KITTITAS VALLEY FIRE & RESCUE

April 28, 2008

I have reviewed the application for the Lookout Large Lot, LL-08-03. I provide review of proposed development and construction for Kittitas County Fire District 2. It should be noted, for information purposes, that the nearest staffed fire station is over five miles from this proposed development and is subject to extended fire and emergency medical service response times. The Fire District has no code enforcement authority so my input is, for the most part, informational only.

DWN BY	DATE	JOB NO.
DP/ST/GW	03/2008	08009
CHKD BY	SCALE	SHEET
D. NELSON	1"=300'	2 OF 3

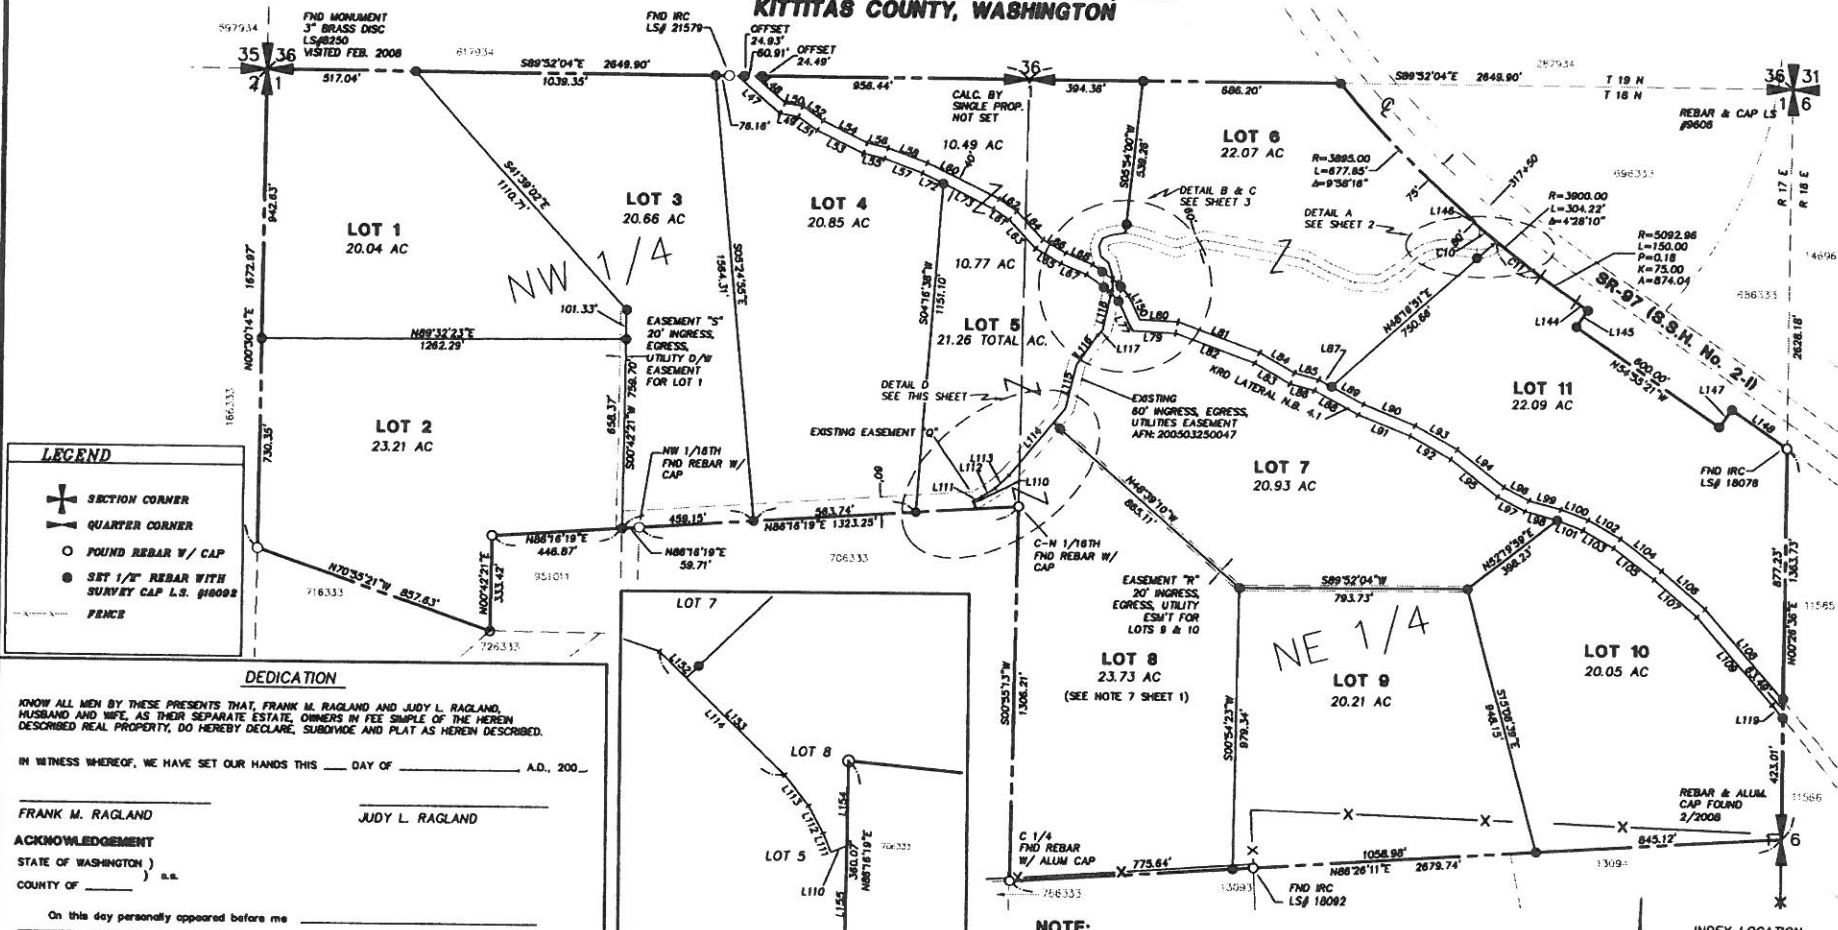
1. The addresses need to be clearly visible from both directions at the county road for all properties.
2. The fire department access road needs to be capable of supporting 75,000lbs in all weather, be 20' wide, provide 13'6" vertical clearance and provide for adequate turn-around for fire department apparatus in accordance with IFC 2006 – Appendix D.
